From: James Cross <James.Cross@arun.gov.uk>
Sent: 25 February 2021 14:37
To: Planning.Responses <Planning.Responses@arun.gov.uk>
Subject: FW: BN/135/20/PL - Boweries

Kerry,
Comments on the additional plans provided.

Access Junction Tracking

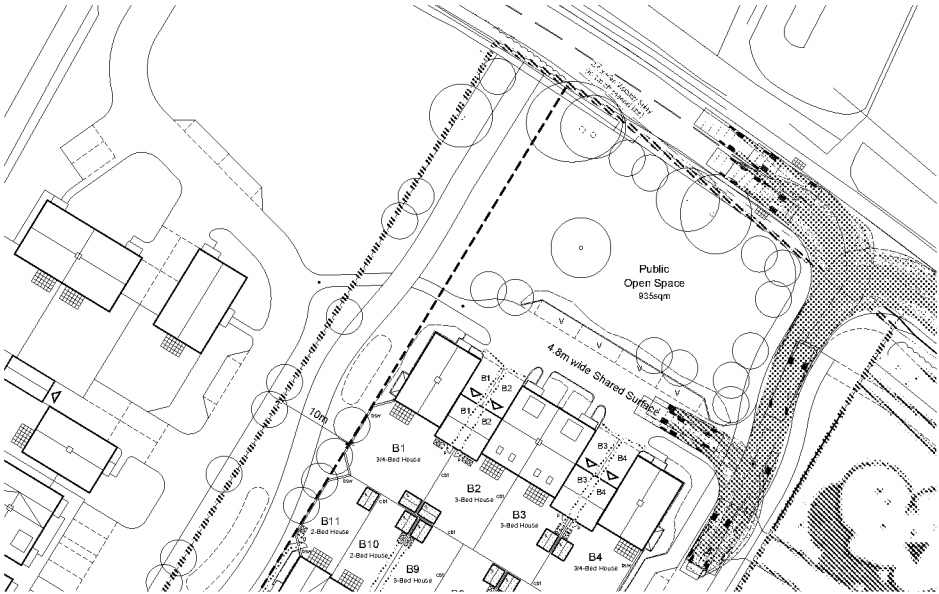
Provision of stage 1 RSA and GG119 appendix F Designers response: Please see attached. The access has changed since the RSA and vehicle tracking shows over run. Given this is one of the issues raised by this should be reassessed. Also Please note this is not a GG119 appendix F Designers response compliant response, the correct template can be found here

Refuse Vehicle Tracking Within Site

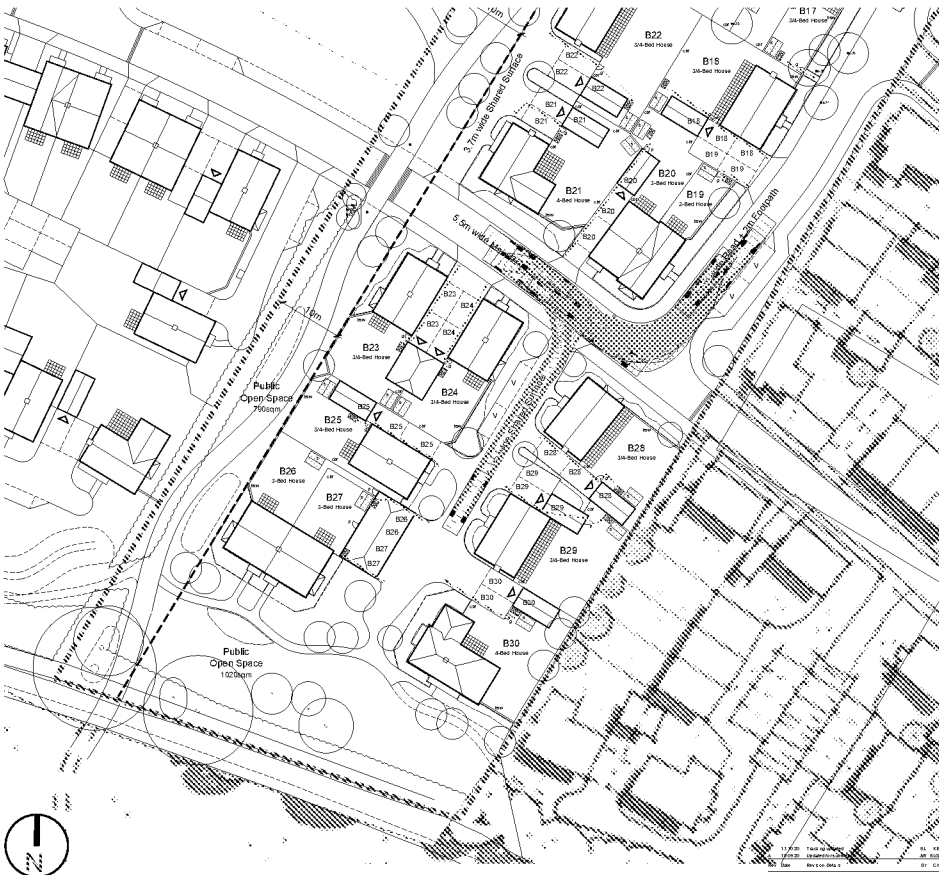
- Appears to over run the kerb (in yellow)
- Provide reverse and carry distances to the southern most properties.
- Noted that a tree appears on this corner on the materials plan
